Appeal Decision

Appeal Ref: APP/T2350/W/23/3333973

Land to the south of Chatburn Old Road, Chatburn, Clitheroe

- The appeal is made under section 78 of the Town and Country Planning Act 1990 (as amended) against a refusal for Technical Design Consent.
 - The appeal is made by Mr Ronald Jackson against the decision of Ribble Valley Borough Council.
 - The application Ref is 3/2022/0500.
The development proposed is Technical Details Consent application following on from Permission in Principle for land to the south of Chatburn Old Road, Chatburn. Site adjoining rear boundaries of Crow Trees Brow, High Beech House and recently approved/developed Hare Hill Croft.
-

Drawing file: planx_downloads / 22_0500_Plot_7_Floor_Plans.pdf

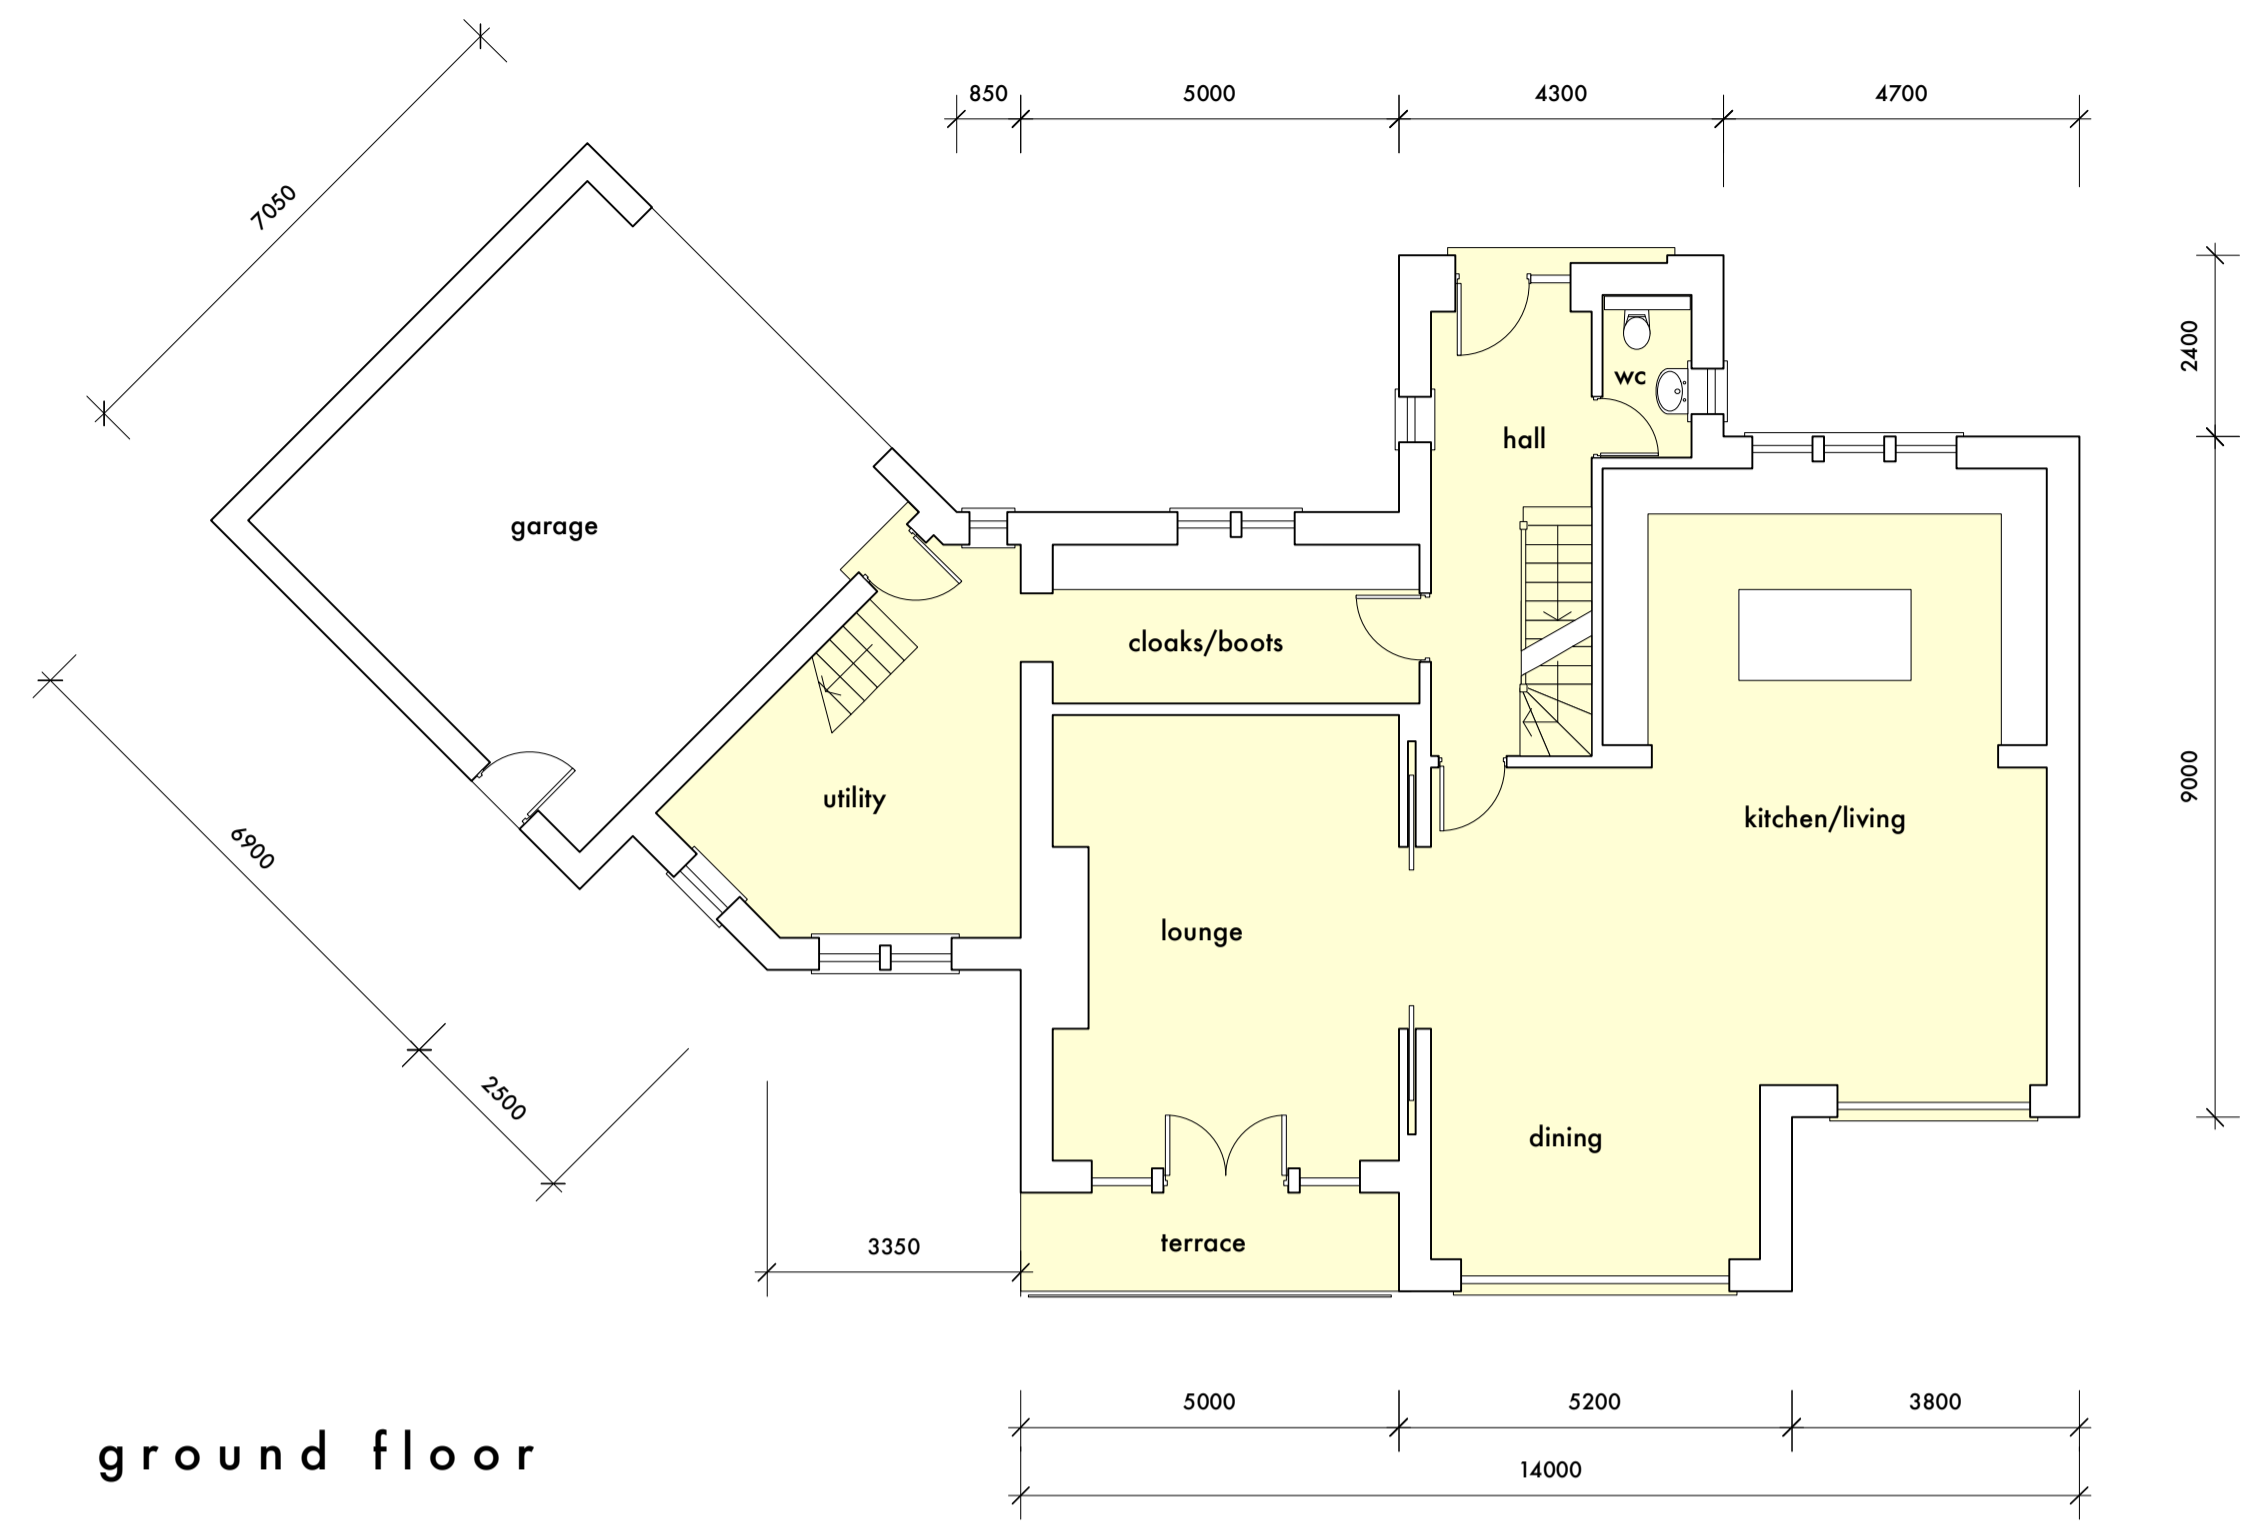
40. The rear elevation for No 7, incorporates floor to ceiling glazing and a balcony, which serve habitable rooms at ground floor, and a first floor bedroom. Based on my observations these, in particular those closer to the boundary with No 26, would allow extensive views over the rear garden of No 26, which would not be limited to the top parts of the garden.

41. Also, some of the windows and the balcony at No 7, serve living, dining and kitchen areas, which are likely to be in use in the day, when the garden associated with No 26 is also likely to be used. The presence of outbuildings / garden structures at No 26 are of limited sizes and would be largely screened by the fence. As such, these and any boundary planting would offer a very limited visual break in the extensive views from the ground and first floor accommodation at No 7.

42. I acknowledge that some mutual overlooking is expected in residential areas. Even so, in this instance the siting of No 7, would be particularly intrusive by introducing a substantial and unacceptable degree of overlooking of the rear garden of No 26. This would significantly undermine the living conditions of the occupiers of this dwelling. As such, the proposal would conflict with Policy DMG1 of the CS, which seeks to protect existing and future residential amenities from undue detrimental impacts.
